Final Acceptance (FA) – Punchlist from EPC Stormwater

Project Name:	Jackson Ranch Filing 3
PCD Filing Number:	SF-17-017
ESQCP #:	ESQ184
Attendees:	DPW: Ben Jones, Molly Layshock PCD: Brad Walters, Lisa Gish, David Parkerson, Spencer Pirzadeh Developer: Marlene Brown, Marshall Brown
Date of Walk-Thru:	11/14/2022
Walk-Thru #:	FA Walk #1

JACKSON RANCH FILING NO. 3 GENERAL NOTES AND DETAILS C1.1 MVE PROJECT 61044 CON-GN MVE DRAWING

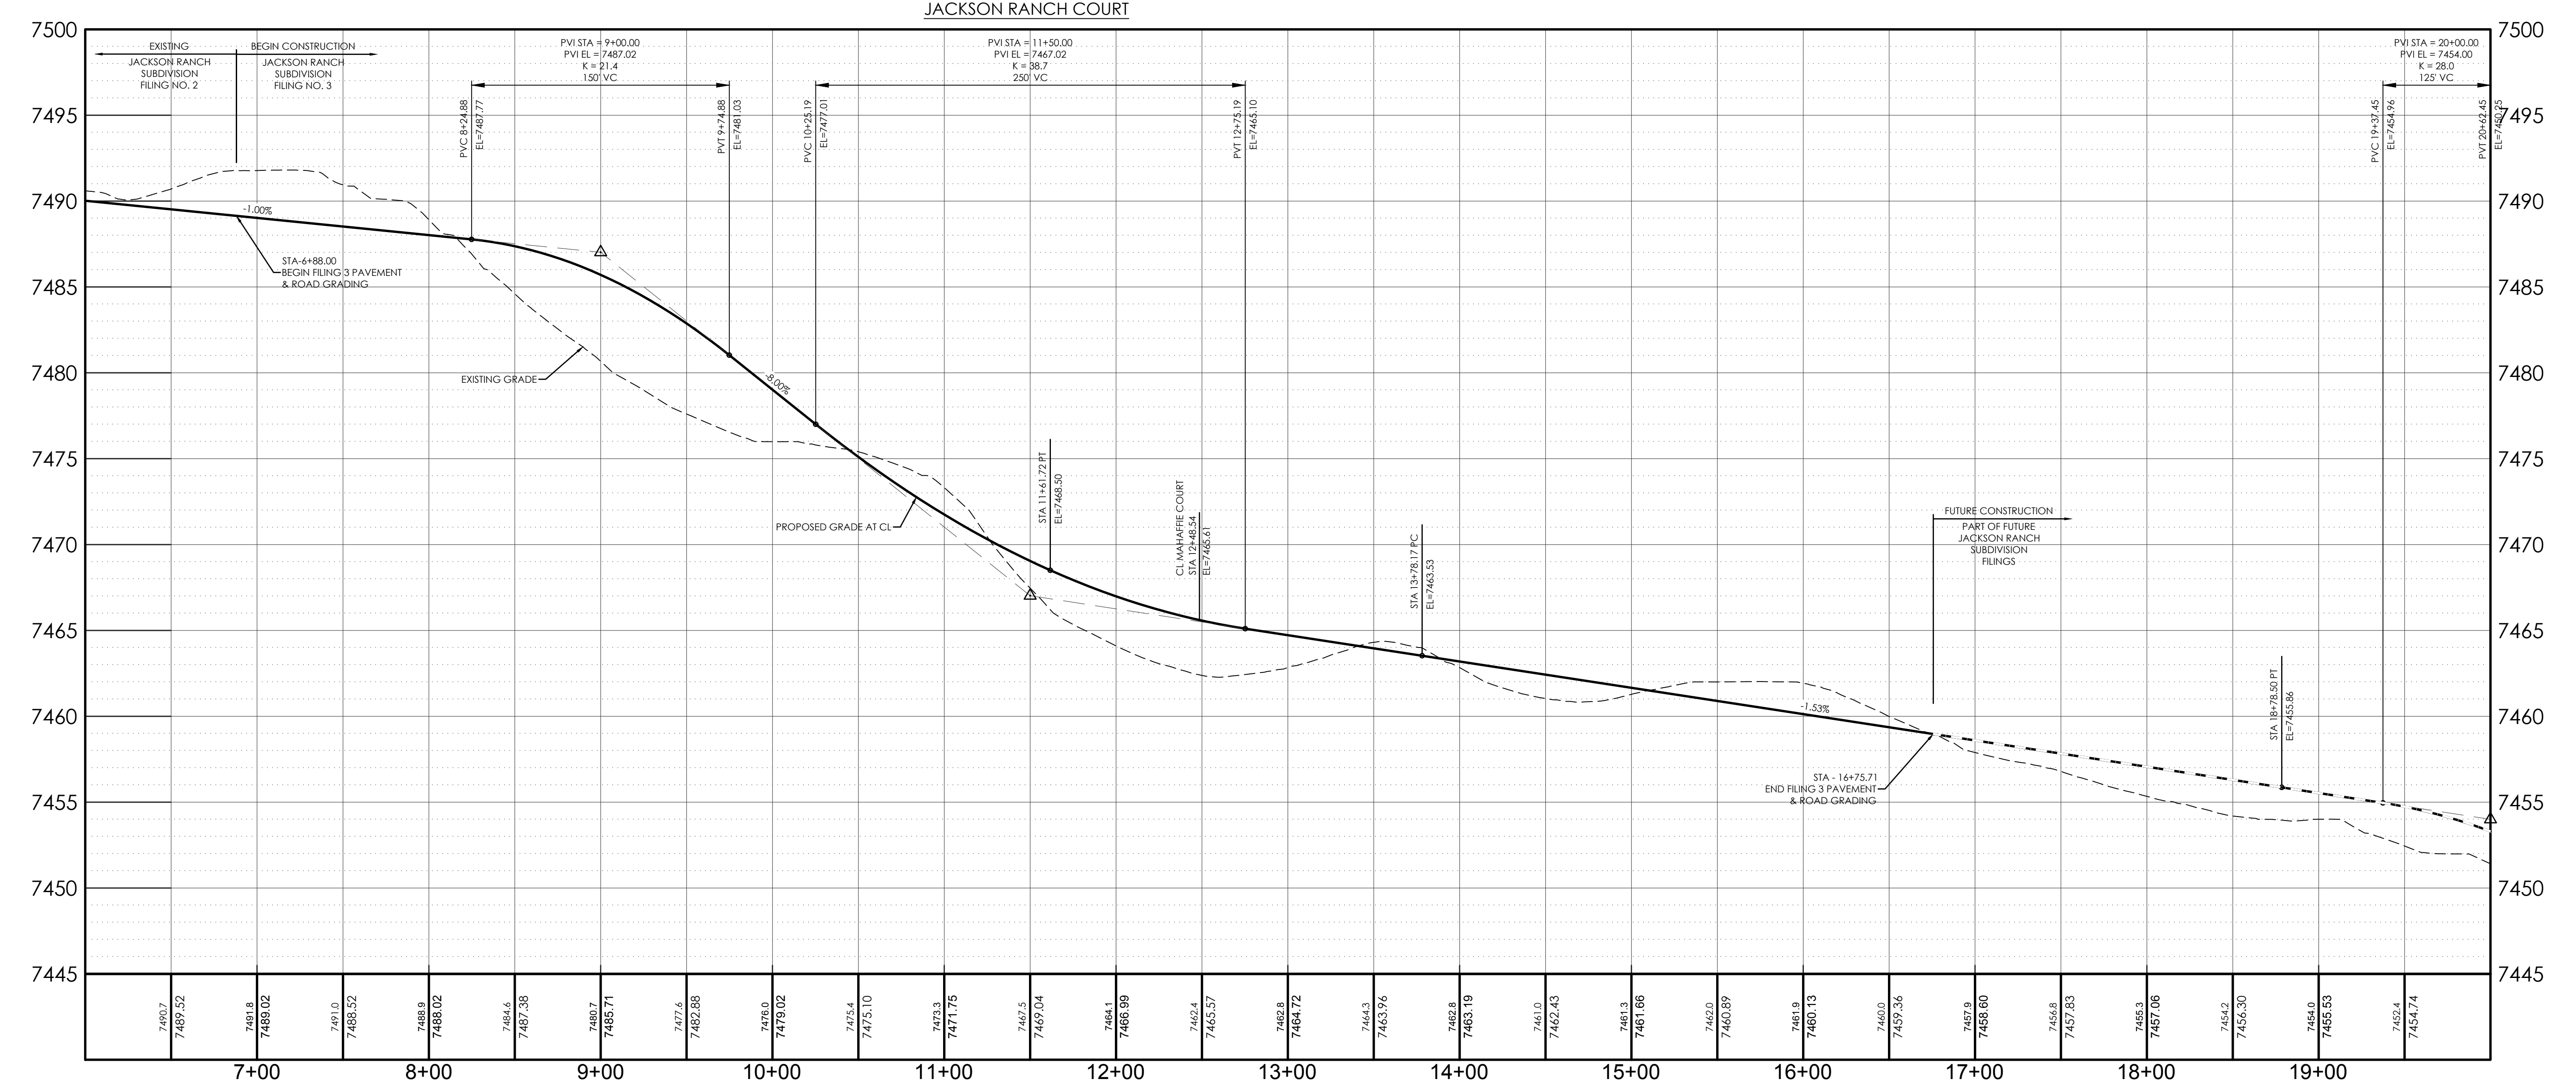
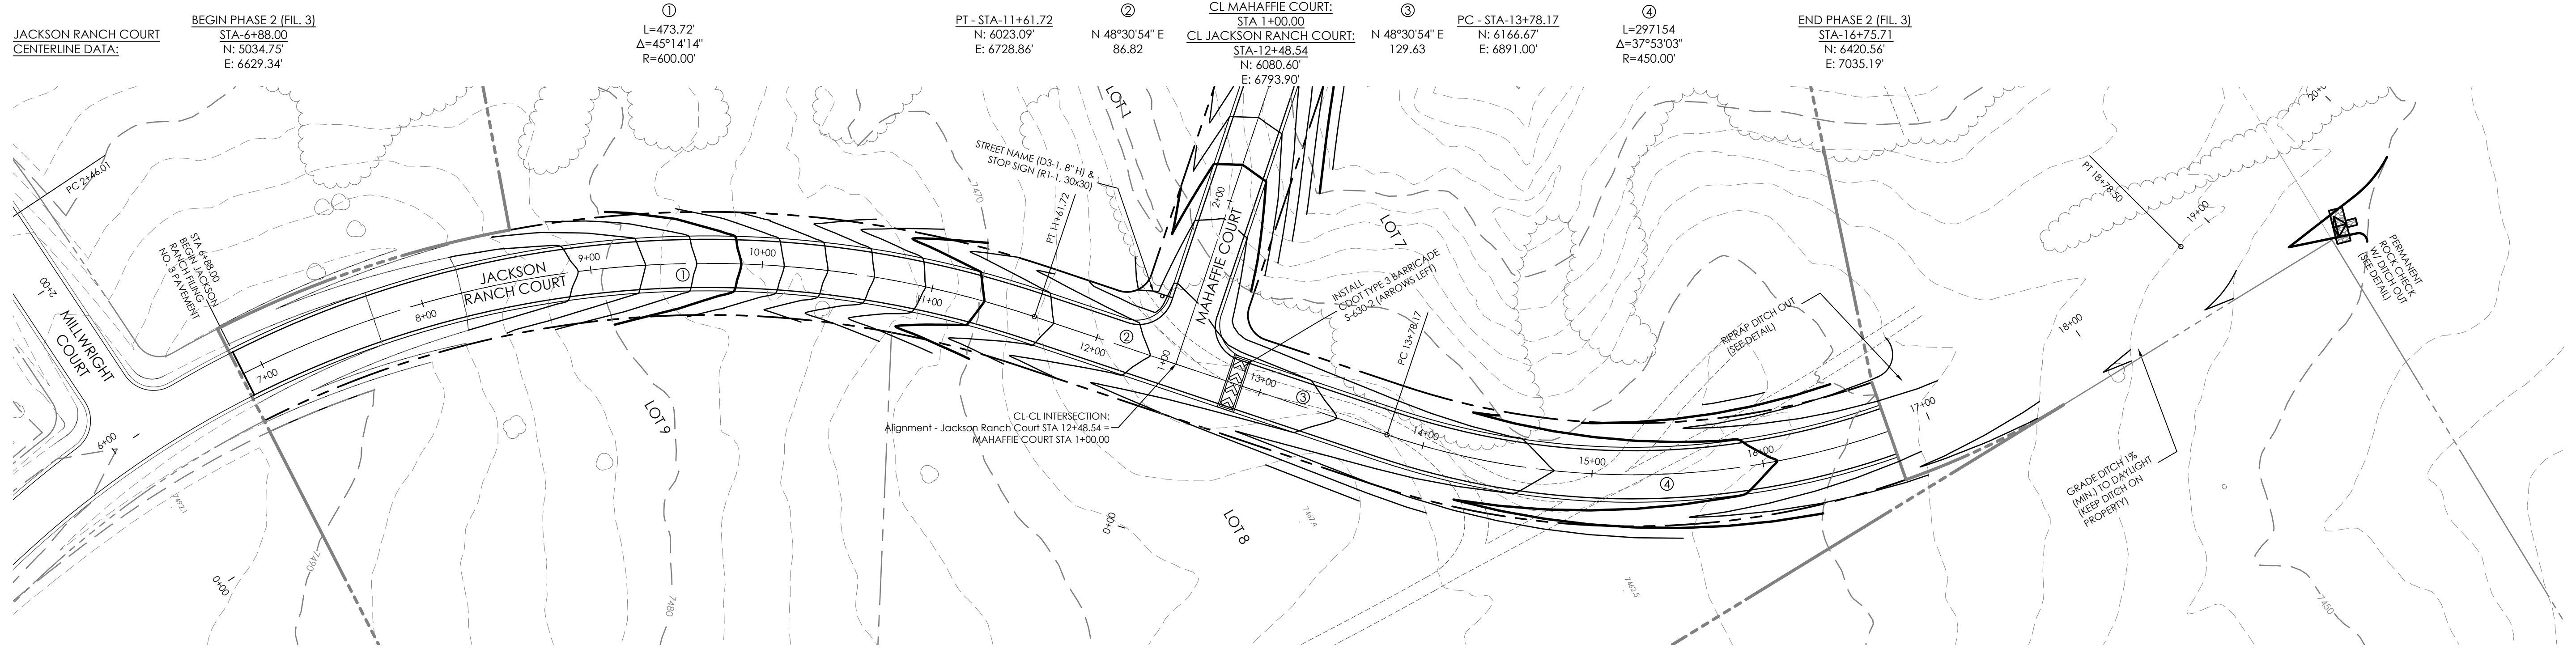
- Permanent rock check with ditch out not installed at end of Mahaffie Court as per Erosion Control Plan C1.4 (detail on page C1.1)
- Need clarification from MVE Inc. Engineers that permanent rock check with ditch out does not have to be installed as per Erosion Control Plan C1.4 (detail on page C1.1)
- Need clarification from MVE Inc. Engineers that spreading pad and section of riprap rundown removed between lots 4 & 5 after PA is not needed (Sheet C1.5 Lot 4 & 5 Drainage Swale)
